A1 in Northumberland: Morpeth to Ellingham

Scheme Number: TR010059

Summary of Proposed Changes to Application

Regulation Reference:	Infrastructure Planning (Examination Procedure) Rules 2010
Planning Inspectorate Scheme Reference	TR010059
Document Reference	TR010059/7.5
Author:	A1 in Northumberland: Morpeth to Ellingham Project Team, Highways England

Key

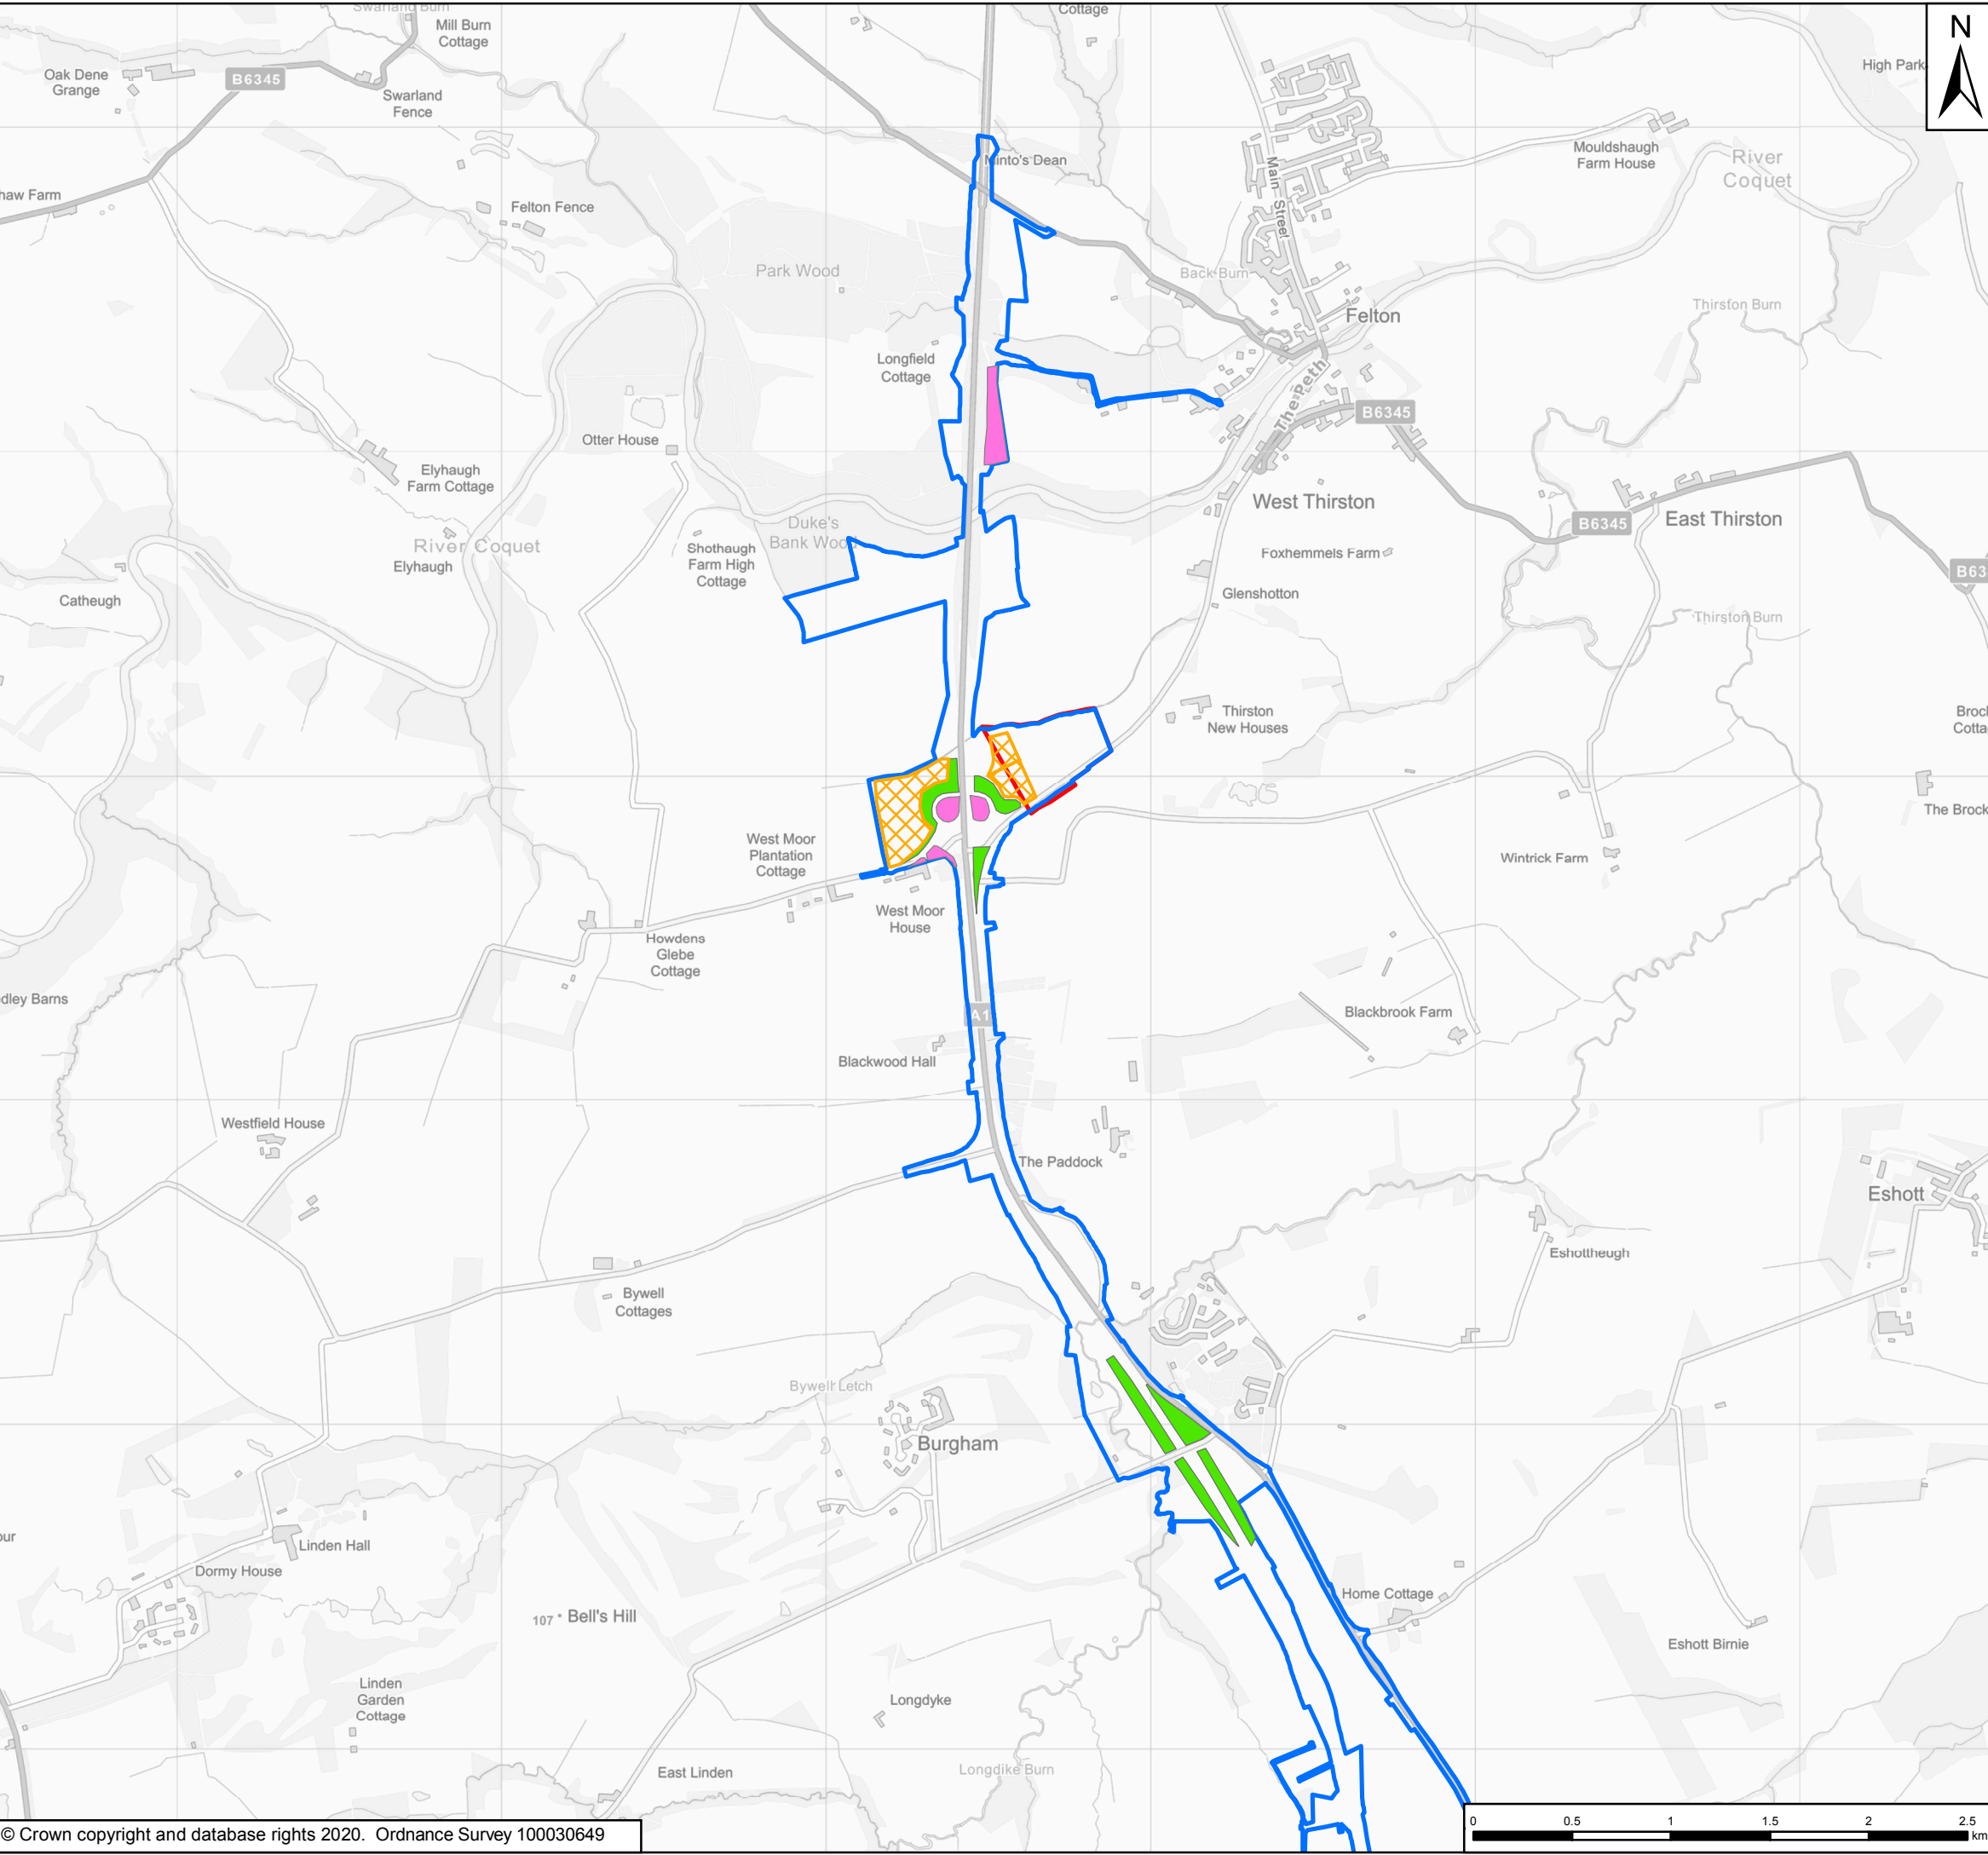
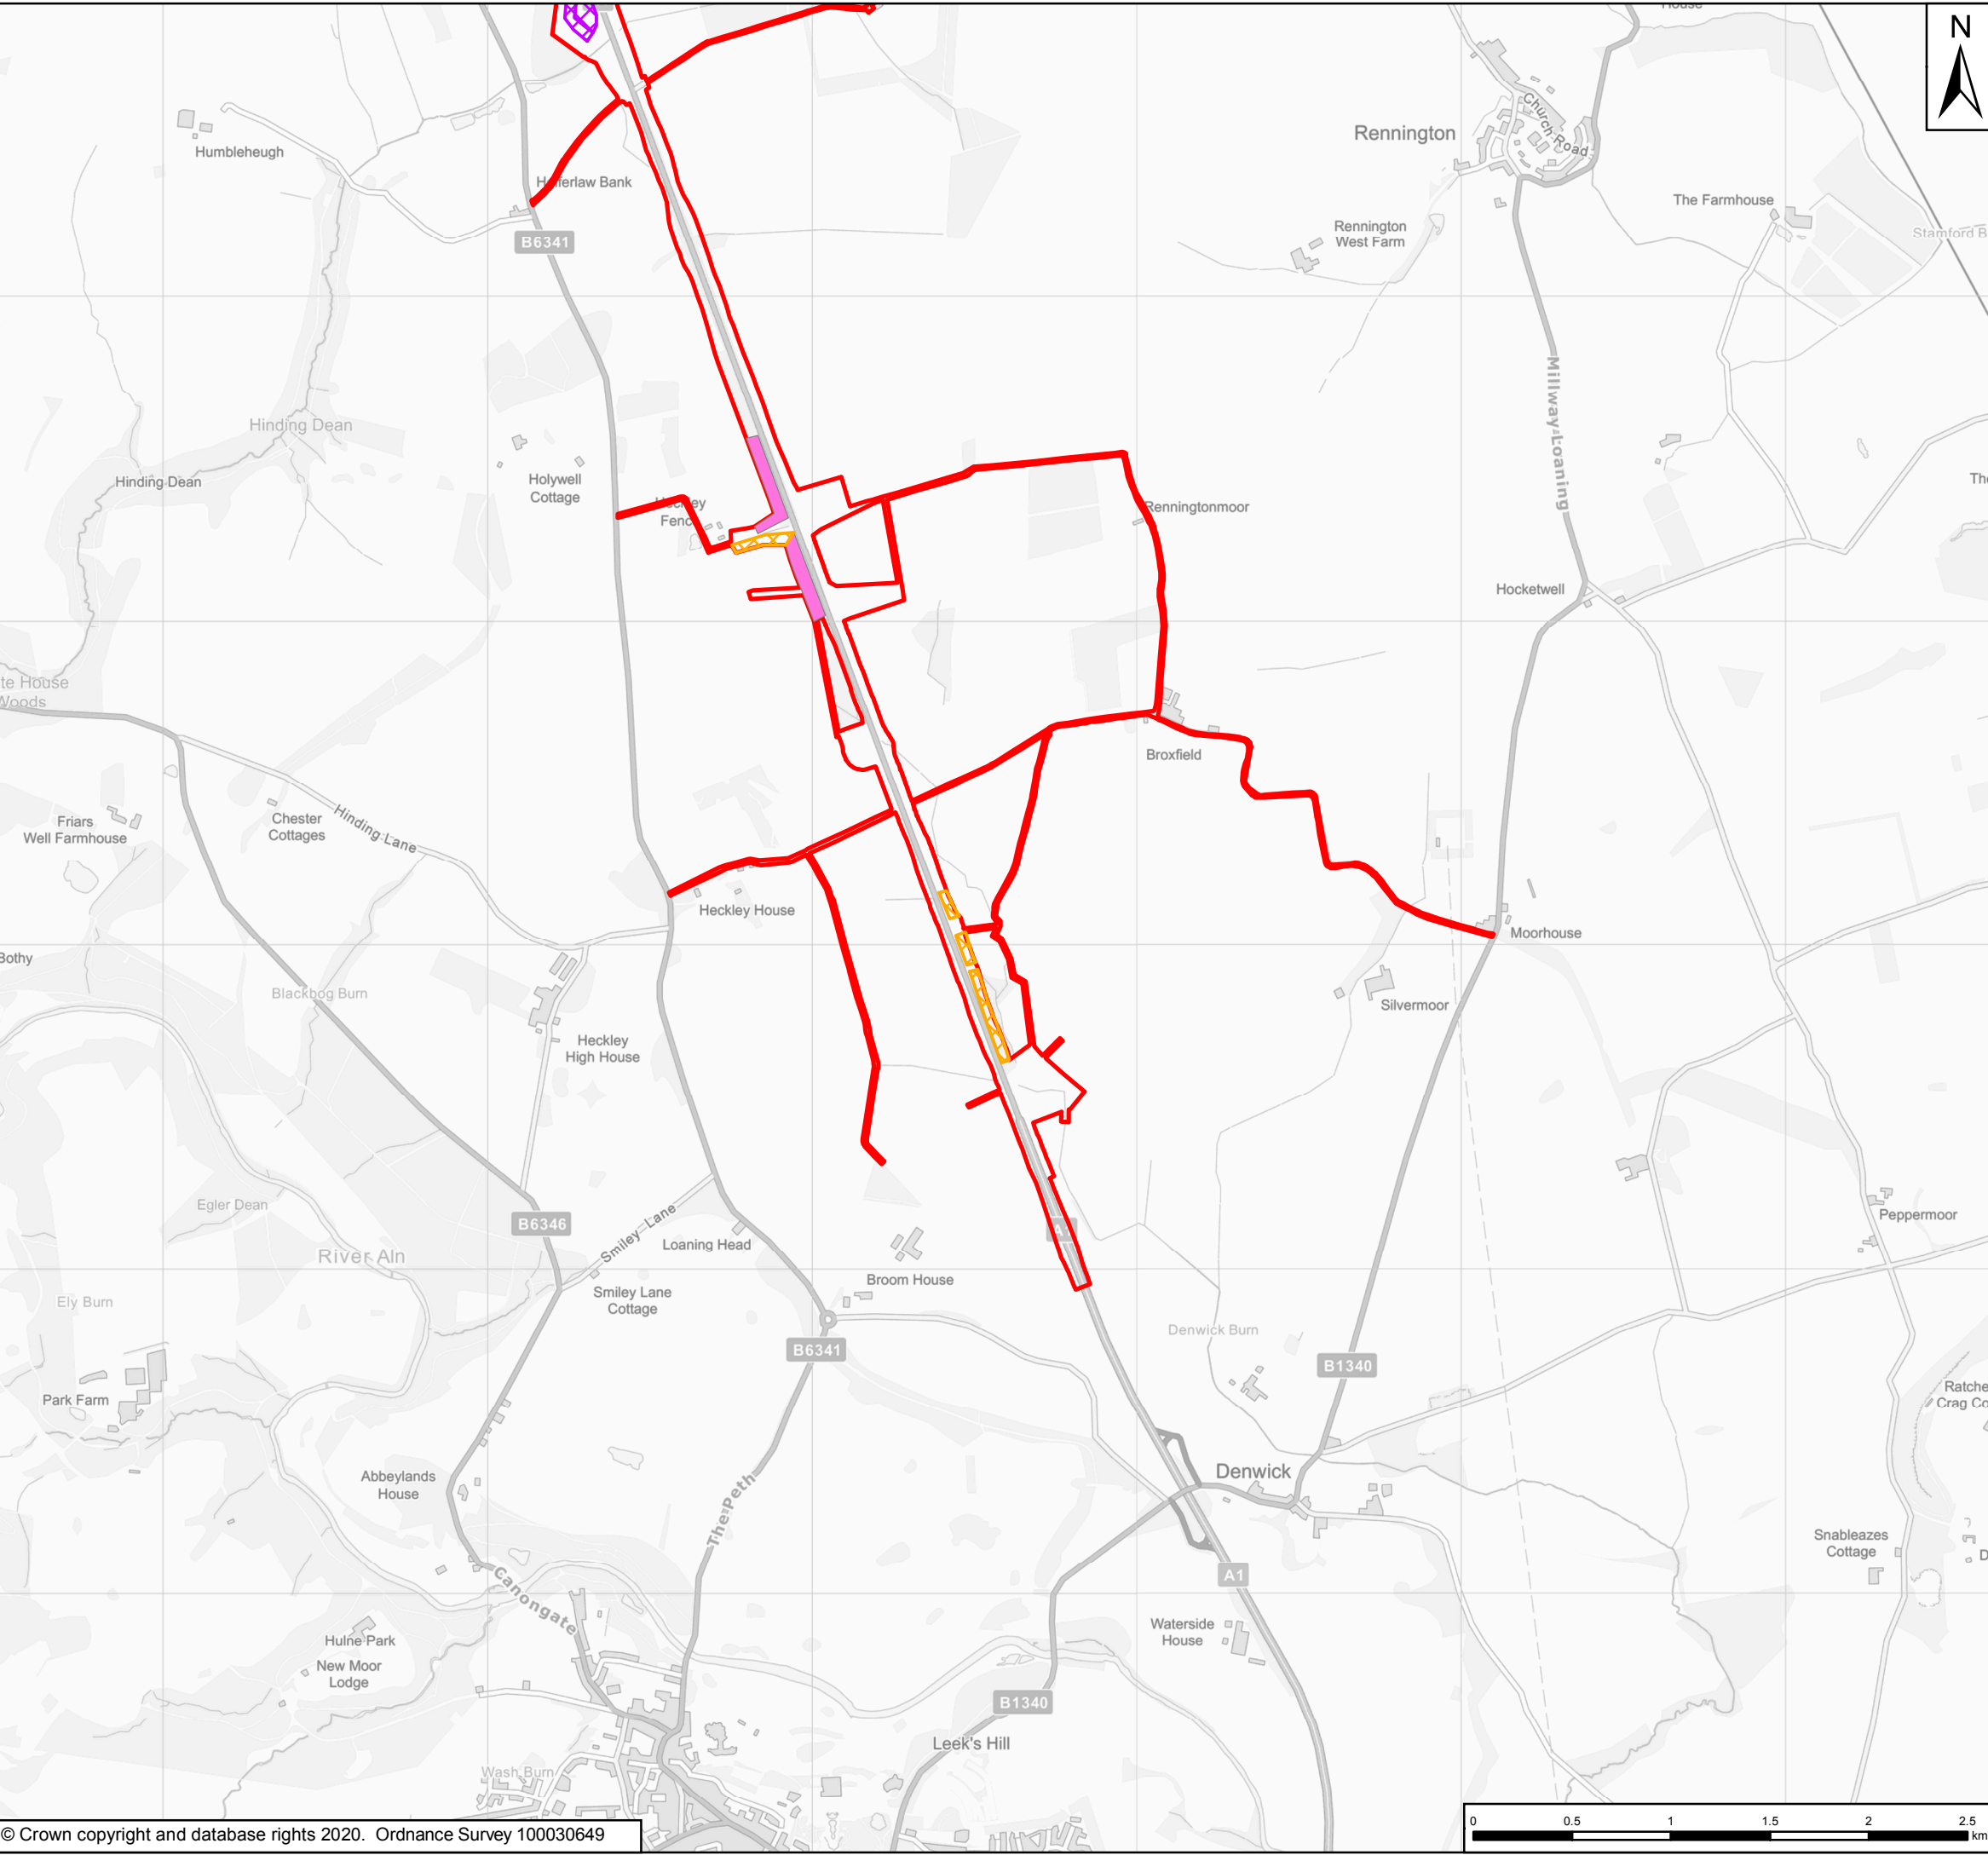
- 2.1.1 The Applicant proposes to maximise the re-use of materials (via excavation, deposition and temporary storage), within the existing Scheme extents. A recent review of the earthworks strategy has identified an opportunity to reduce earthwork movement and as a result greater flexibility in temporary and permanent storage of Site won material is required to achieve this. The indicative earthworks areas are shown in the figure in the **Indicative Earthwork Change Locations** figure in **Appendix A**.

- 2.1.2 To balance materials across both Parts A and B, the following methods are proposed:
- Utilising borrow pits to exchange and win additional material suitable for construction.

- Creation of new soil bunds within Part B to maximise re-use of excess site material.
 - Maximising of slopes for re-use of excess site material, in Part B.

- Laying down additional material increasing some localised ground levels.
 - Raising levels of junction “bowls” (level or rounded rather than dished).

- Creating new, temporary soil storage areas within both Part A and Part B.
- 2.1.3 These changes are an alteration to Parameters 4 and 5 for Part A, as set out in **Chapter 2: The Scheme** of the ES [APP-037]. There would also be additional temporary and permanent earthworks that require assessment for Part A and Part B. Therefore, it is appropriate to ensure that the environmental information before the Examination addresses the prospect of altered impacts This is addressed by sensitivity testing as described at **paragraph 2.1.6** below.
